Recommendation Report for Planning Permission

REF NO: P/157/21/PL

LOCATION: 31 Lagoon Road
Pagham
PO21 4TQ

PROPOSAL: Demolition & erection of 1 No dwelling (resubmission following P/56/21/PL). This site is in CIL Zone 4 and is CIL Liable as new dwelling.

0q. Proposed Street Scene

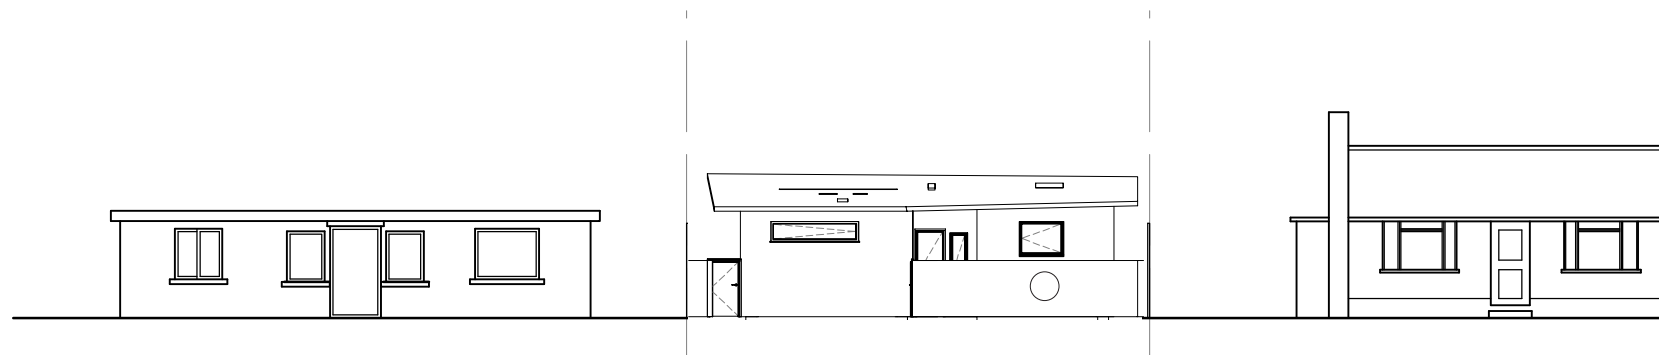
The new dwelling clearly respects policy and guidance relating to Areas of Character as it respects the single storey nature of the estate, has its own design which is different to nearby dwellings and proposes render and timber boarding. The proposal is therefore in character with its surroundings and it is noted that no objections have been raised in respect of design considerations. The two building approach means that the footprint is larger than before (117m² vs 109m²) but this is not detrimental to character and the overall plot coverage is less than 45% which accords with guidance in the PVDS.

Concerns have been raised about a front boundary treatment. This will be 1.5m high and will create a private front courtyard on half of the frontage. There is no policy in HER DM4, the associated SPG or the PVDS to prevent front boundaries provided that they contribute to the streetscene. There is a similar height boundary to the frontage of 42 Lagoon Road a short distance to the east and the presence of this is material to this part of the proposal. Nevertheless, the proposed boundary will have only a neutral effect on the streetscene and is therefore acceptable.

South Elevation

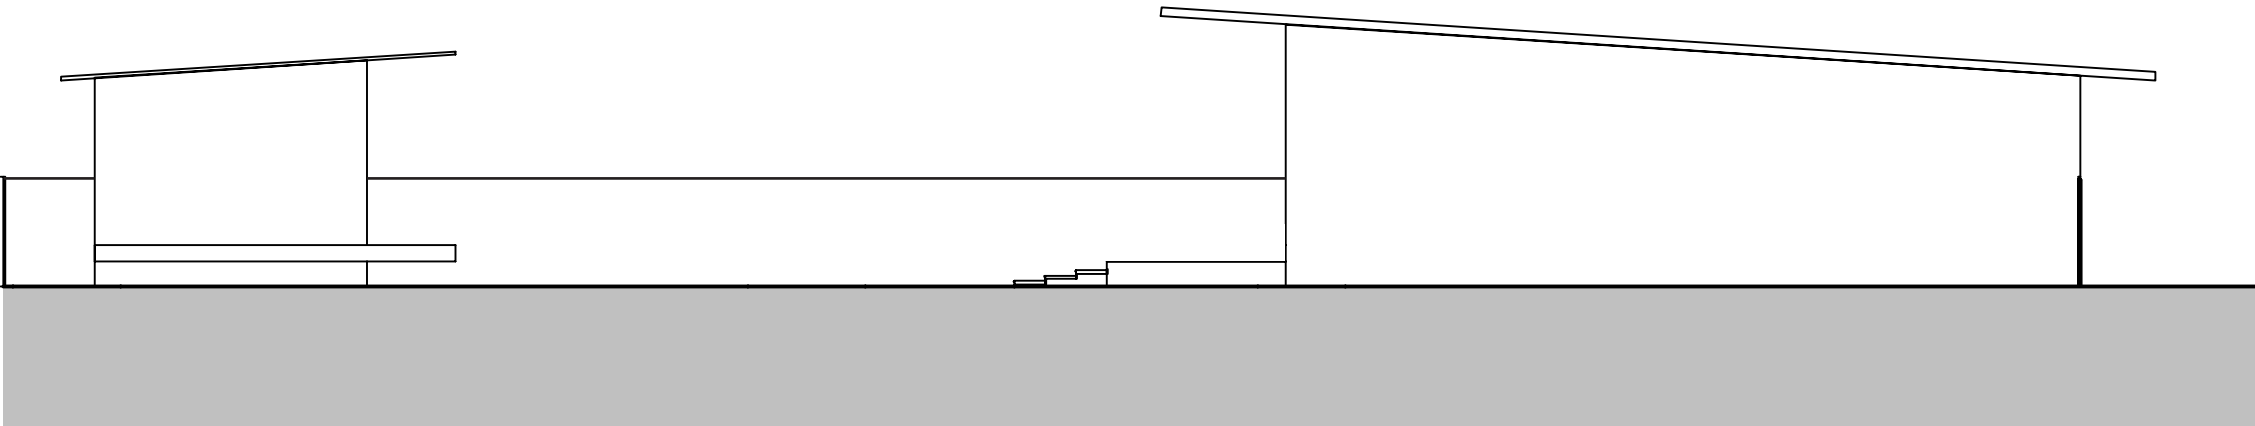
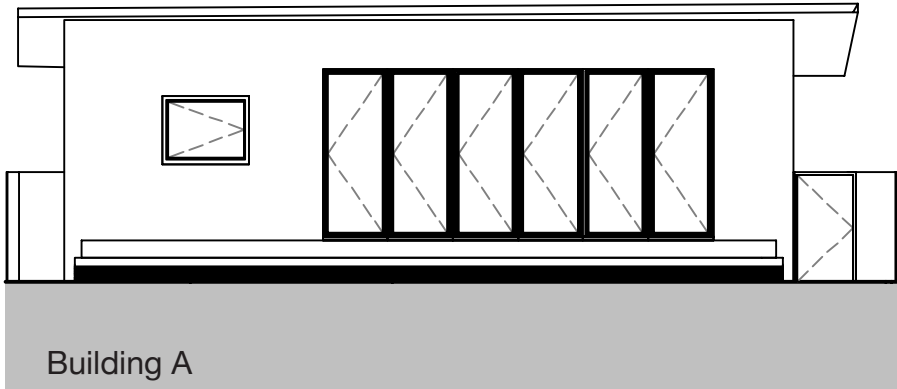
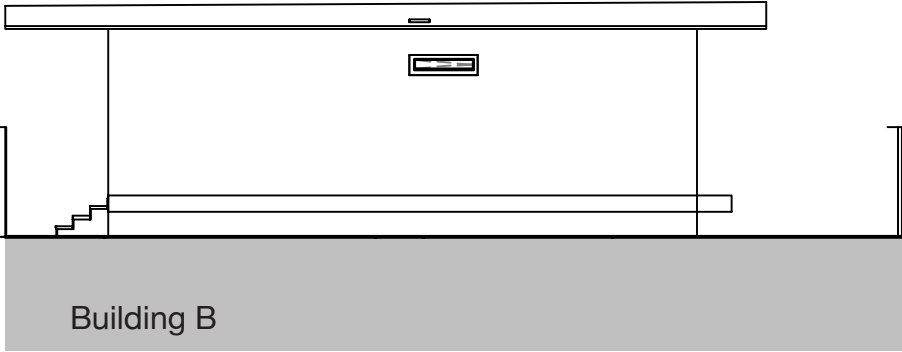
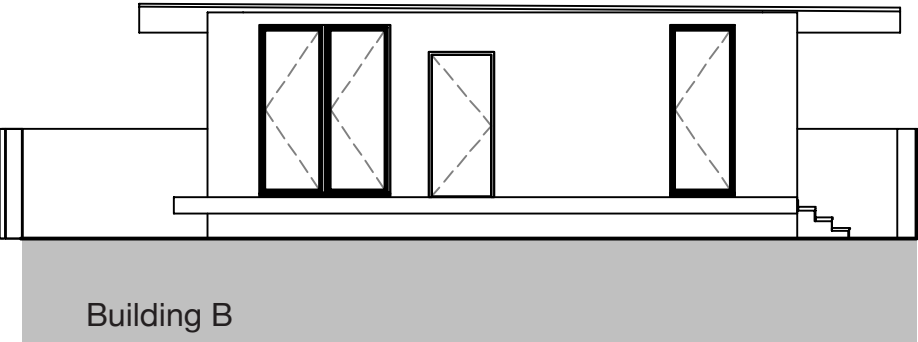
- Building B harms privacy (particularly from the proposed rear bathroom window) & outlook of neighbours;
- proposed holiday let requires a change of use and will cause noise & disturbance;
- straw bale construction with render is a fire risk;
- need construction management plan to manage delivery of materials and students on the site during construction;
- need details of front boundary wall height; and
- why two buildings?

The exception is the bathroom window on the rear elevation of building B which will face towards a neighbouring garden. This is part screened by the existing boundary fence and the applicant has no objection to it being obscure glazed. The applicant states it is for light only and so it can be fixed shut. Given its single storey nature & low roof, this building will not have a significantly harmful impact on the outlook or light of the adjacent property. The proposal is in accordance with ALP policies D DM1 and QE SP1.

- 13 The rear bathroom window in building B shall be permanently glazed with obscured glass and fixed to be permanently non-opening.

01. Proposed Ground Floor Plan

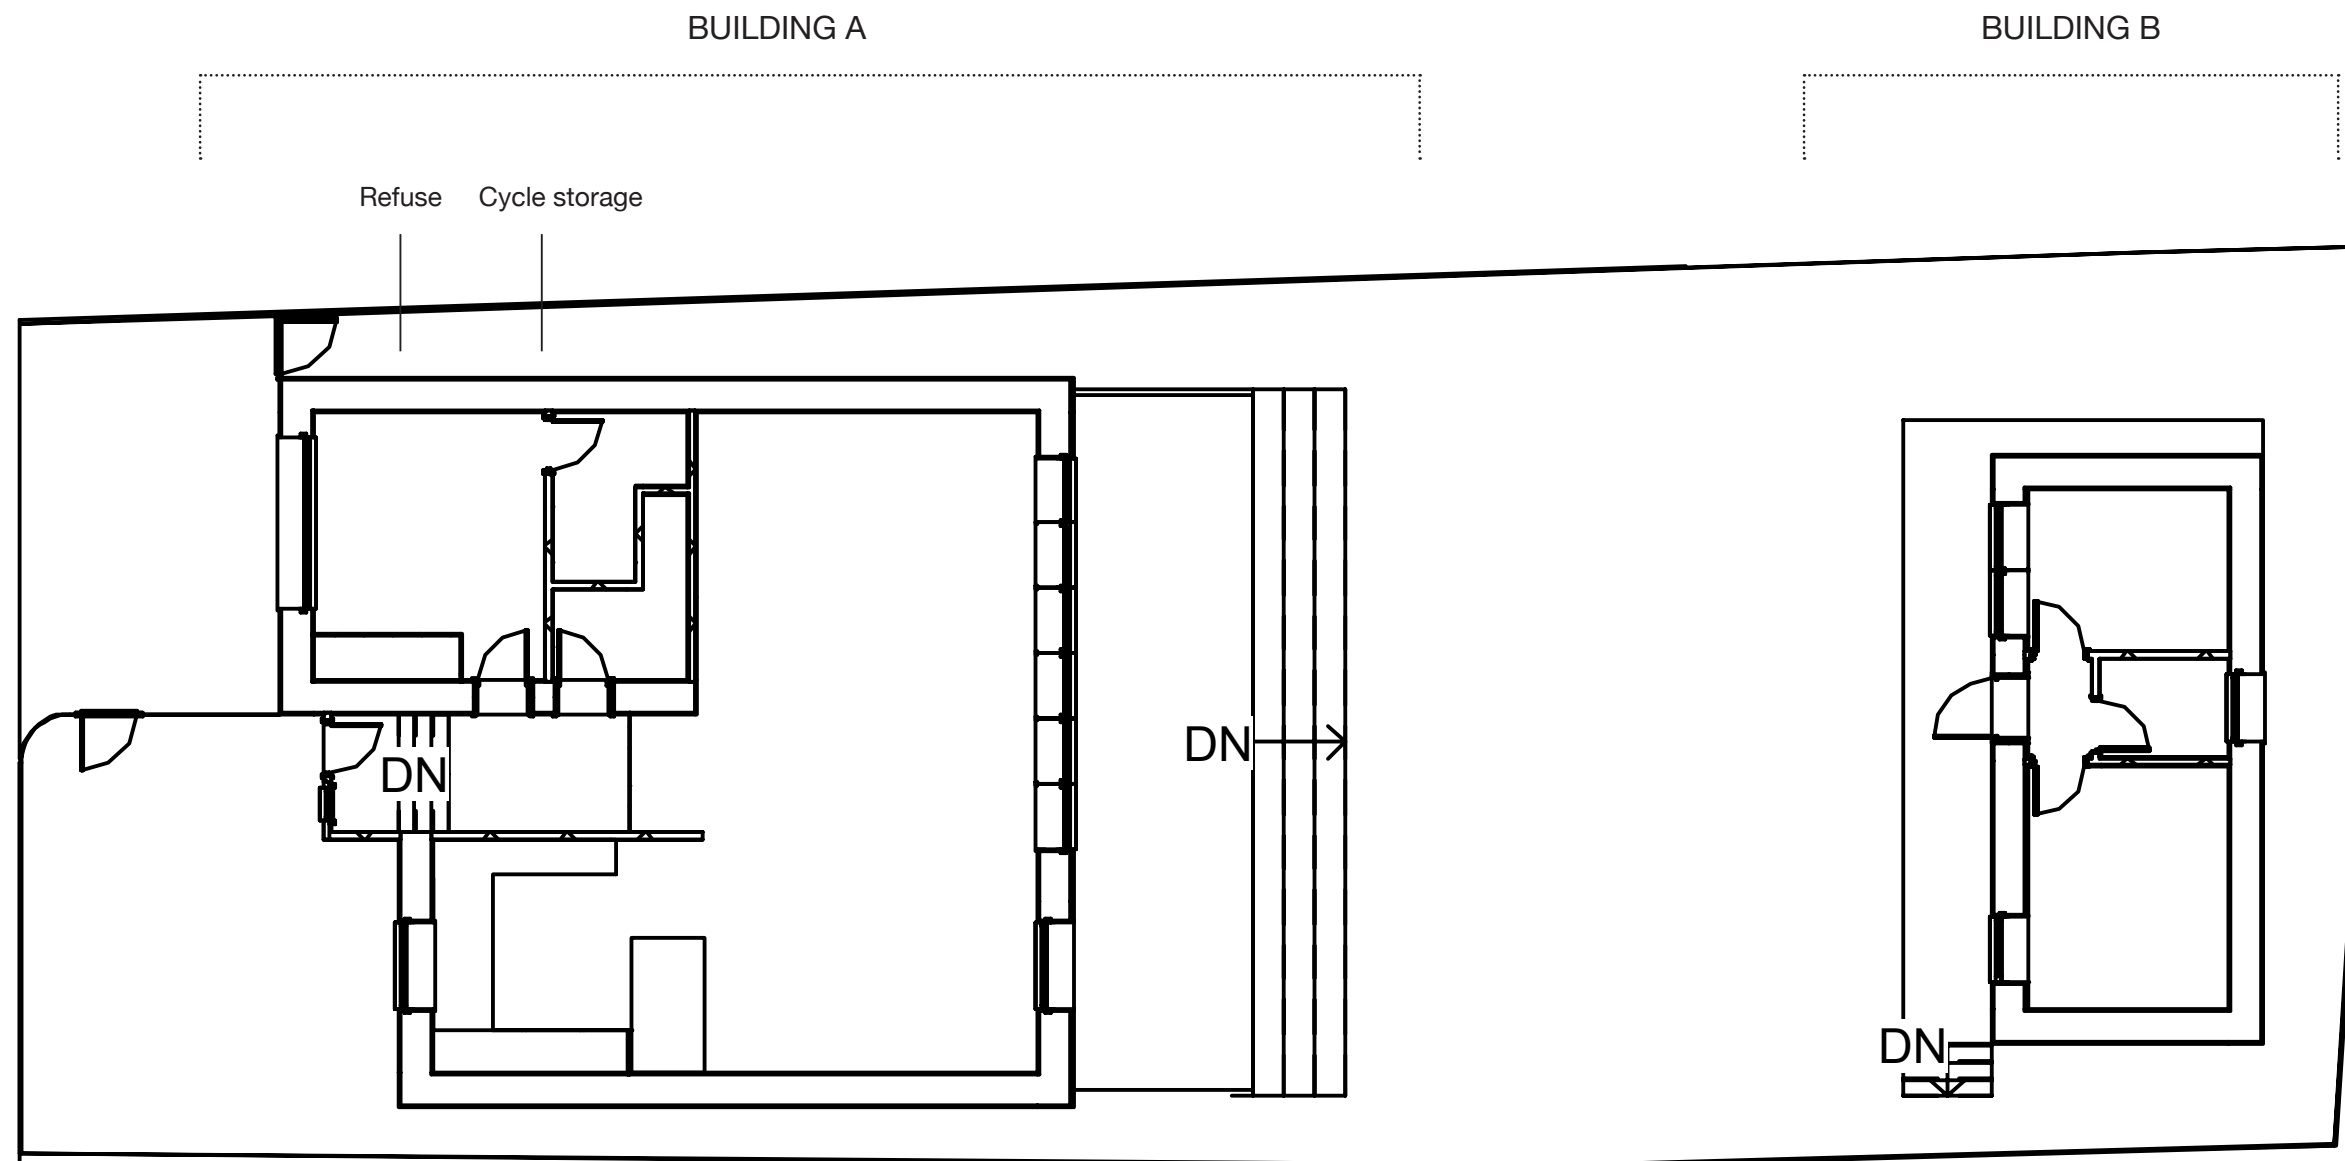
ALP policy D DM2 states that internal spaces should be of an appropriate size and that the Nationally Described Space Standards provide guidance. The required internal space standard for a single storey, 3 bedroom, 5 person house is 86m² and the scheme proposes a general internal area of 117m² so complies with the requirement. The Arun Design Guide sets out standards for garden sizes as follows:

01. Proposed Block Plan 1:500

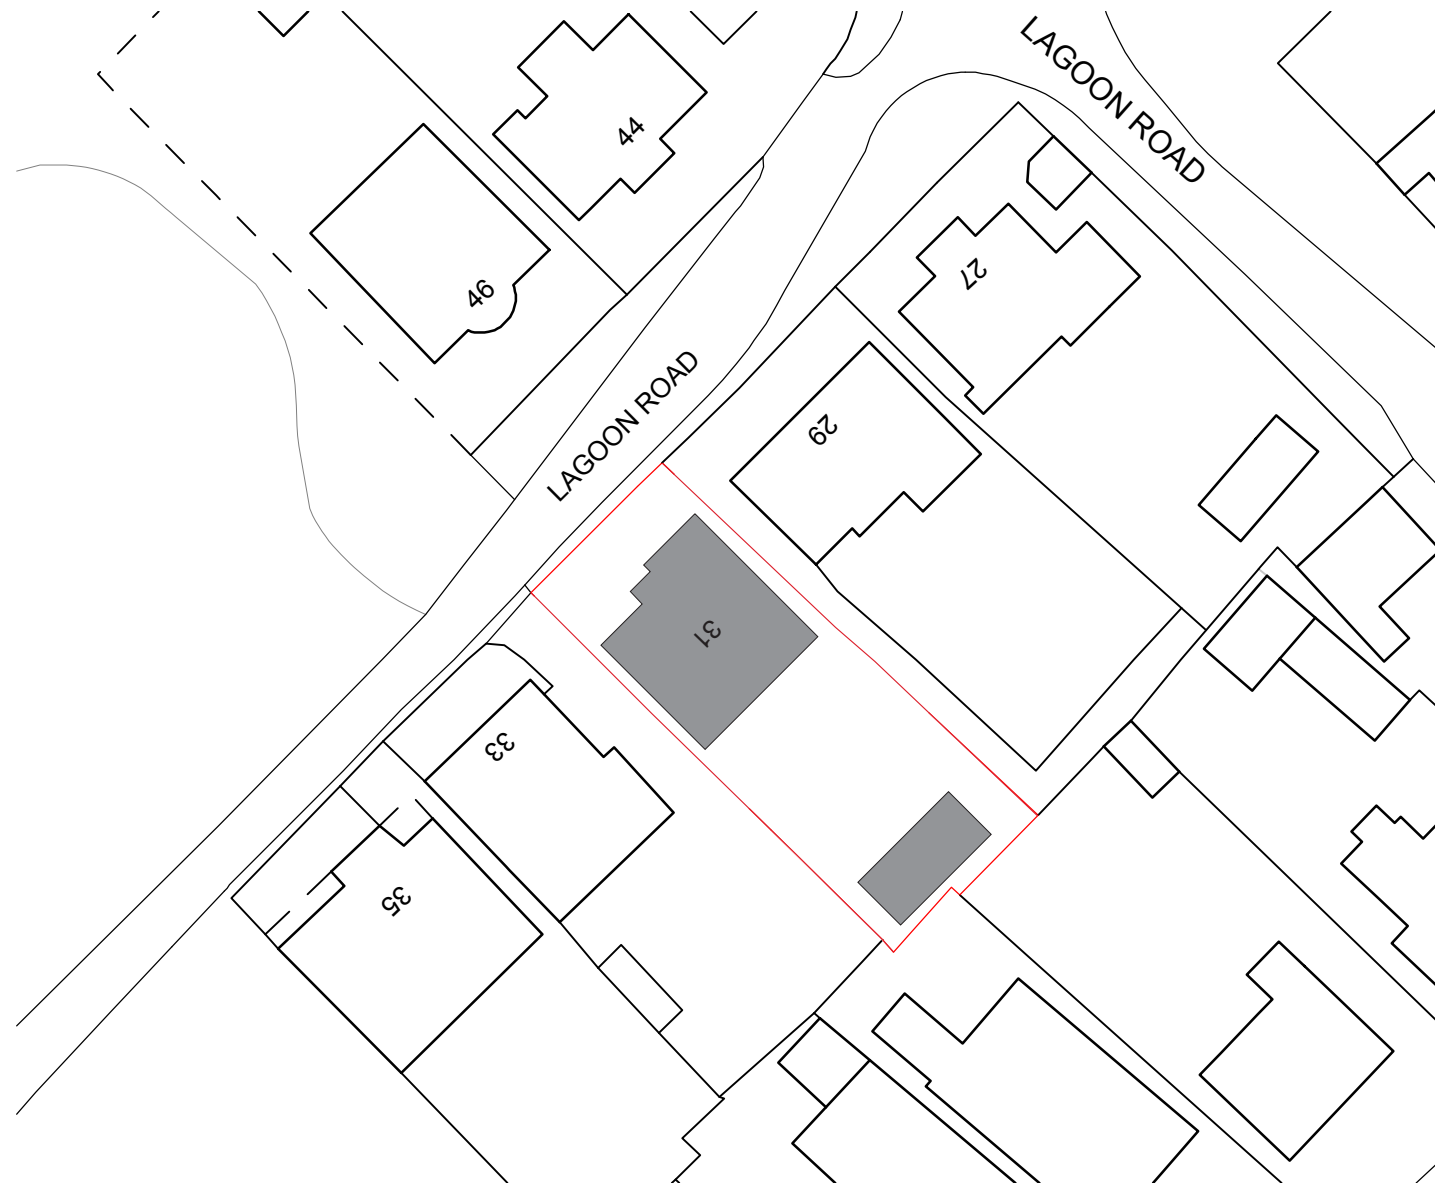
The space in the rear garden between buildings A and B is around 13m whilst there is a front set back of at least 4m. The scheme provides a decent standard of amenity for future occupiers and there is no conflict with development plan policy or guidance.

- the front boundary fence is shown as being 1.5m high.
